Addendum No. 1

RE: Contract ID: C202458 WBS# 45226.3.ST1 F.A. # STM-095-3(105)123 Wilson, Nash Counties (I-5137) I-95 From Joint North of MP 123 To Nash County Line and From Wilson County Line To The Tar River

# October 20, 2009 Letting

## SUMMARY OF QUANTITIES

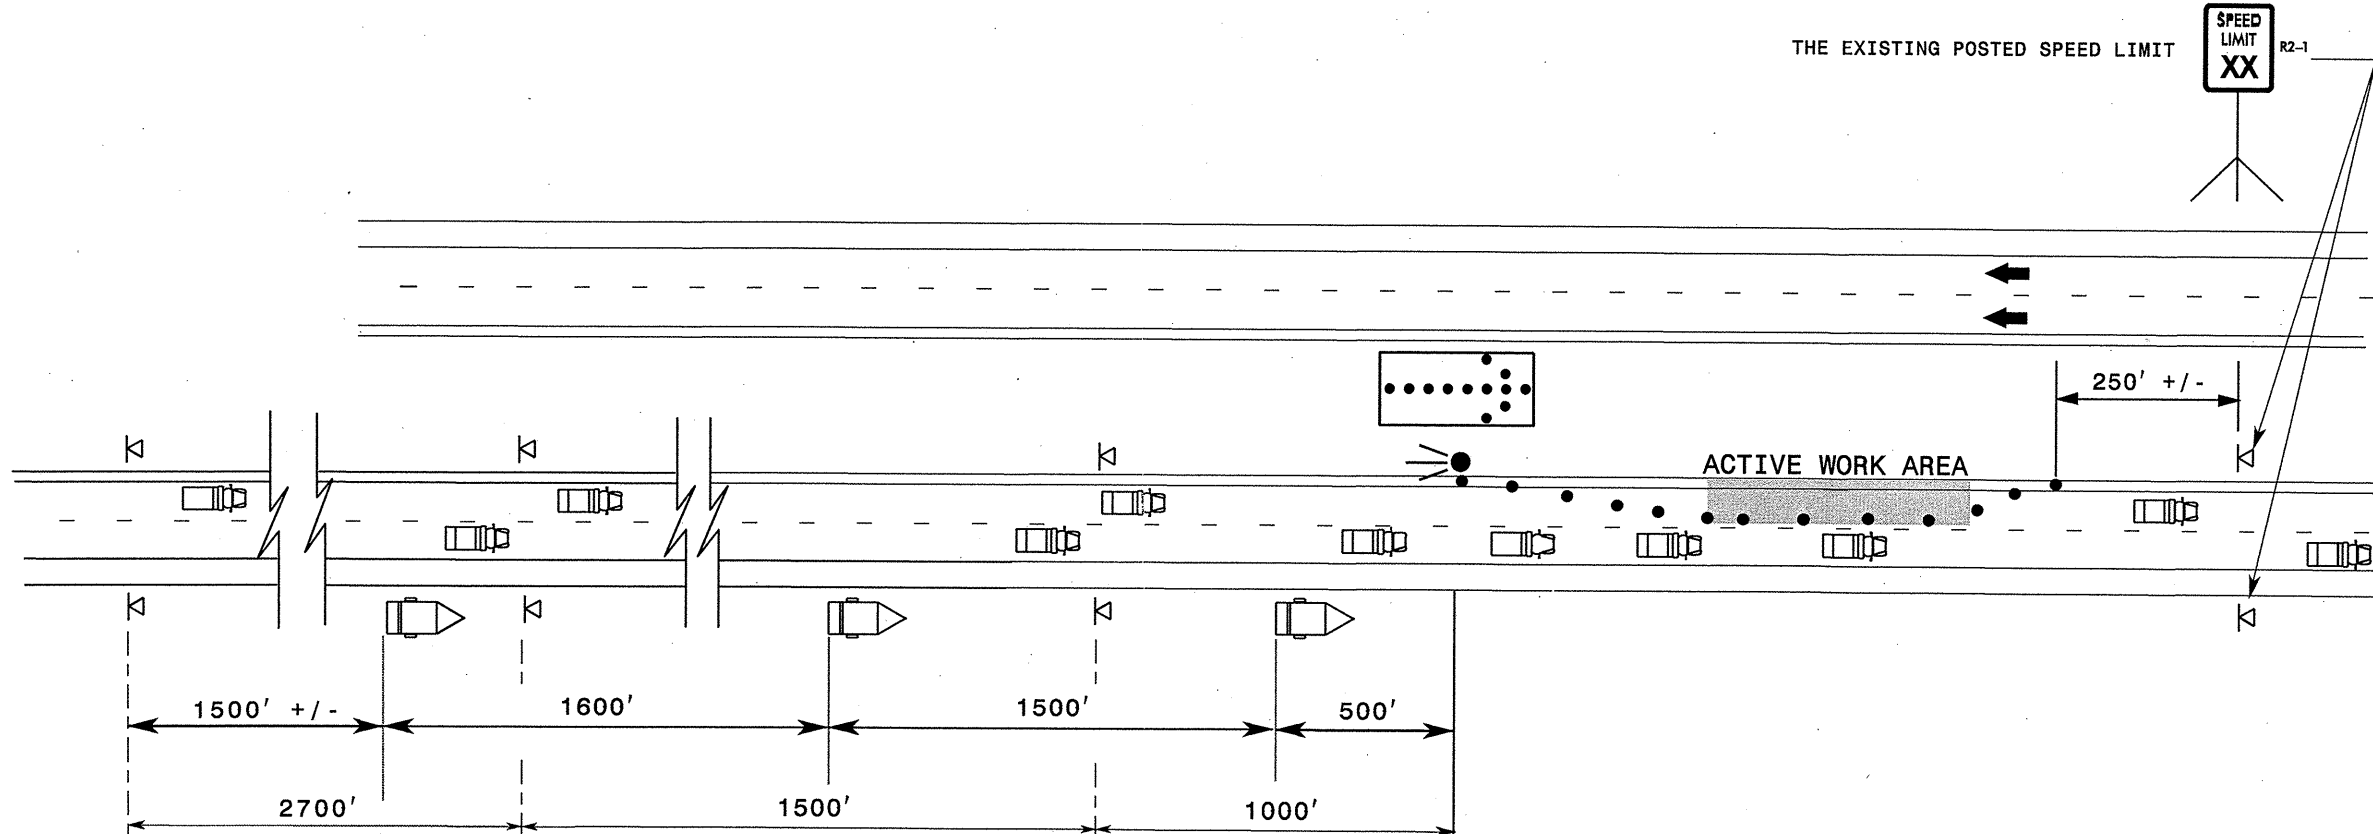
On Sheet No. 3 the Summary of Quantities has been revised to add a column for Seeding and Mulching.
